**GRADING & EROSION CONTROL PLANS OF PROPOSED  
CIMARRON HILLS SOUTHEAST FILING NO. 1  
SOUTHWEST QUARTER OF SECTION 8, TOWNSHIP 14 SOUTH, RANGE  
65 WEST OF THE 6TH P.M  
EL PASO COUNTY, STATE OF COLORADO  
AUGUST 2024**

EPC STORMWATER REVIEW COMMENTS  
IN ORANGE BOXES WITH BLACK TEXT

MATCHLINE SHEET GEC02-INITIAL GRADING & EROSION CONTROL PLANS (SHEET 2 OF 2)

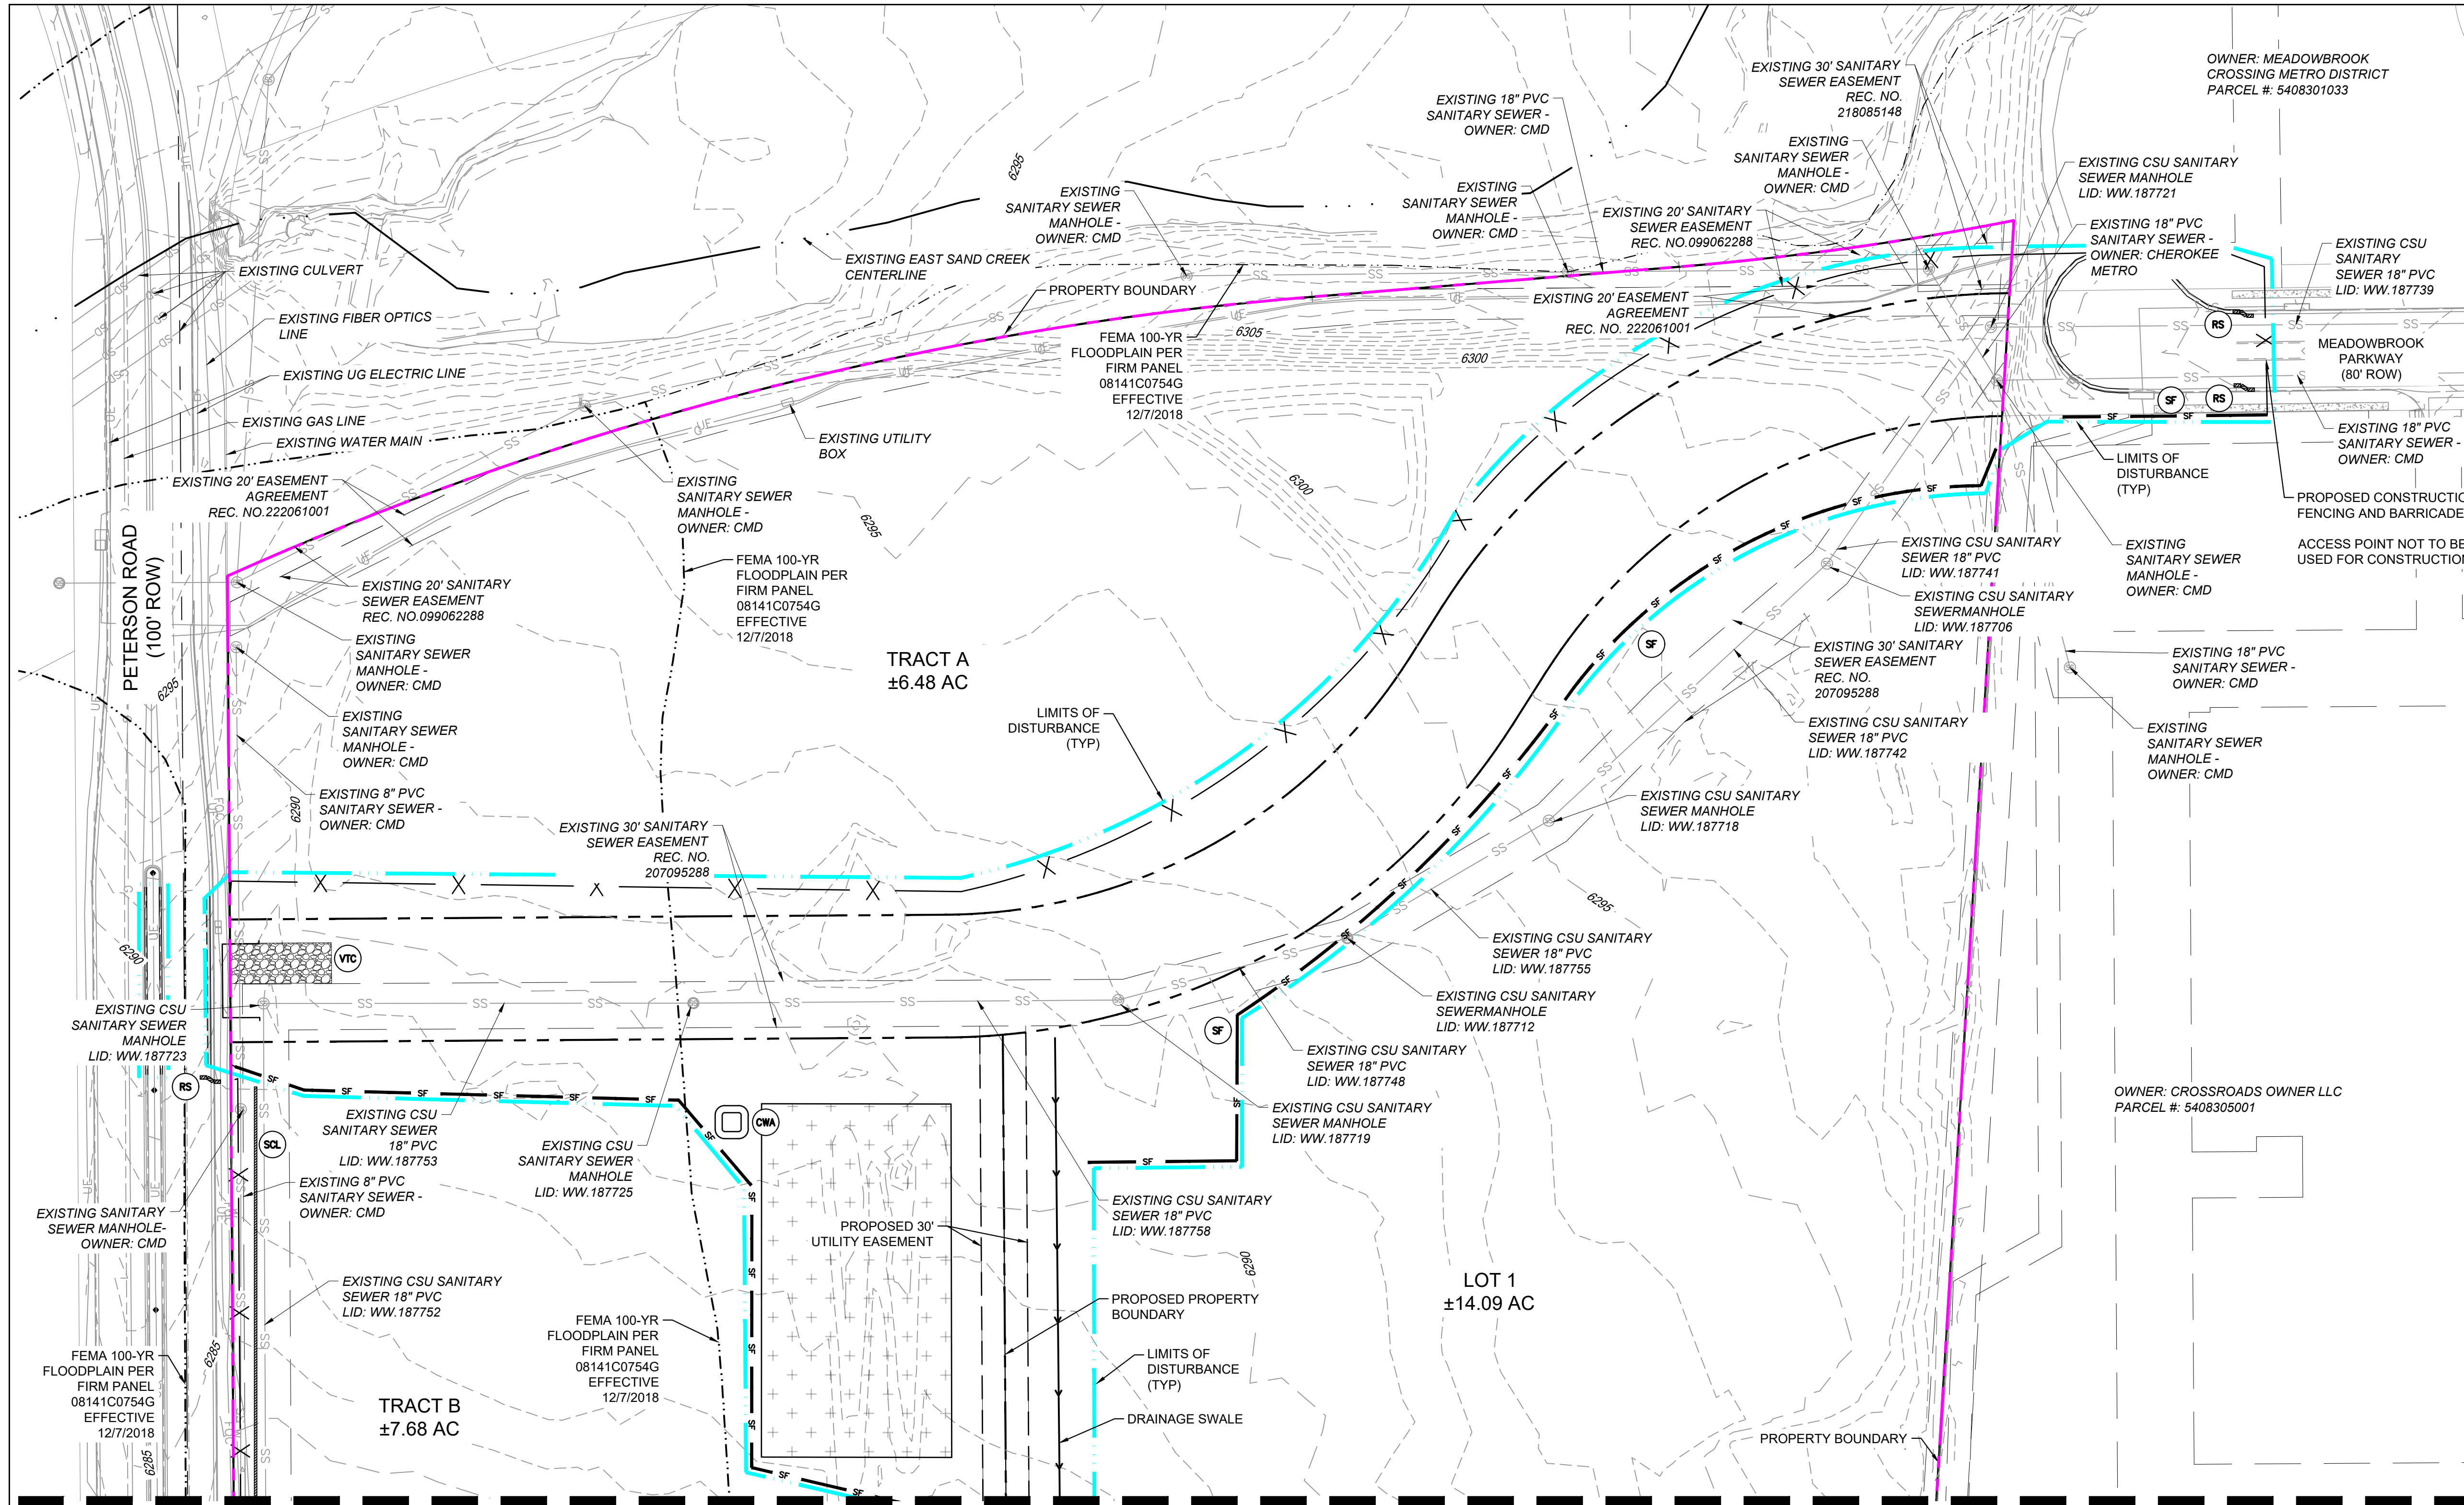
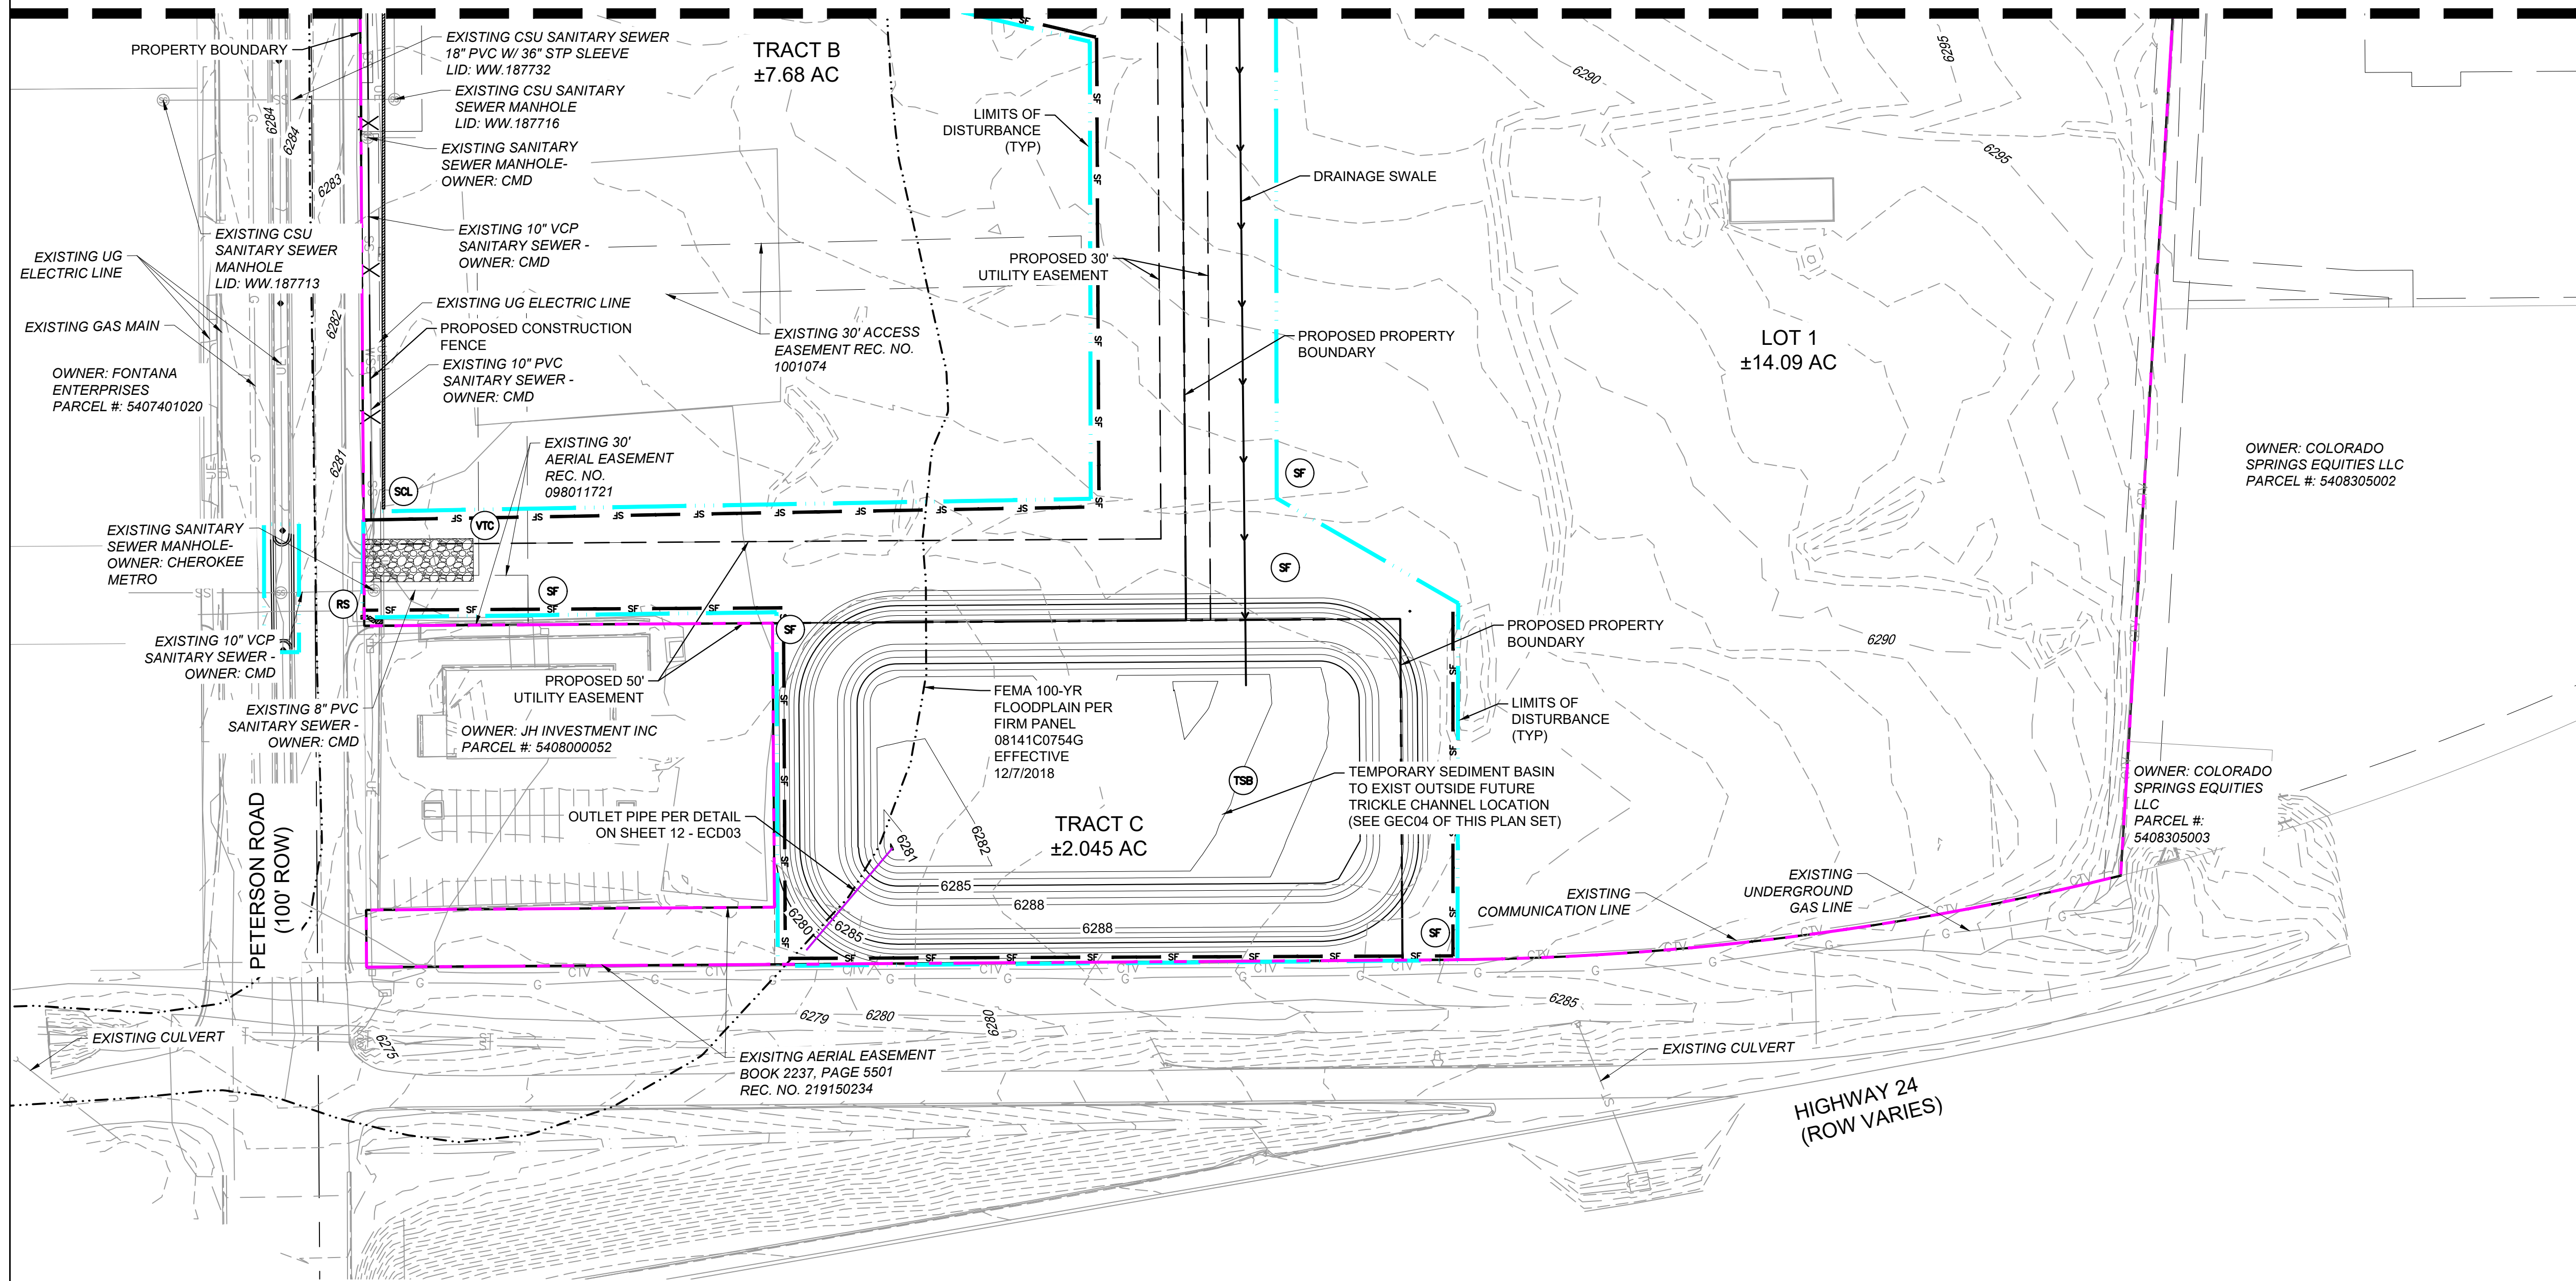
Provide construction fencing, barricades, and/or signage at access points not to be used for construction.

add a note about existing vegetation  
To comply with the SWMP Checklist Item 17f, please add a note stating no batch plants will be utilized onsite.

Provide details of temporary sediment basin including riser pipe diameter and perforation sizing, number of rows of holes, required volume, location of outlet pipe and spillway, and tributary area to the sediment basin. And provide contours for sediment basin.
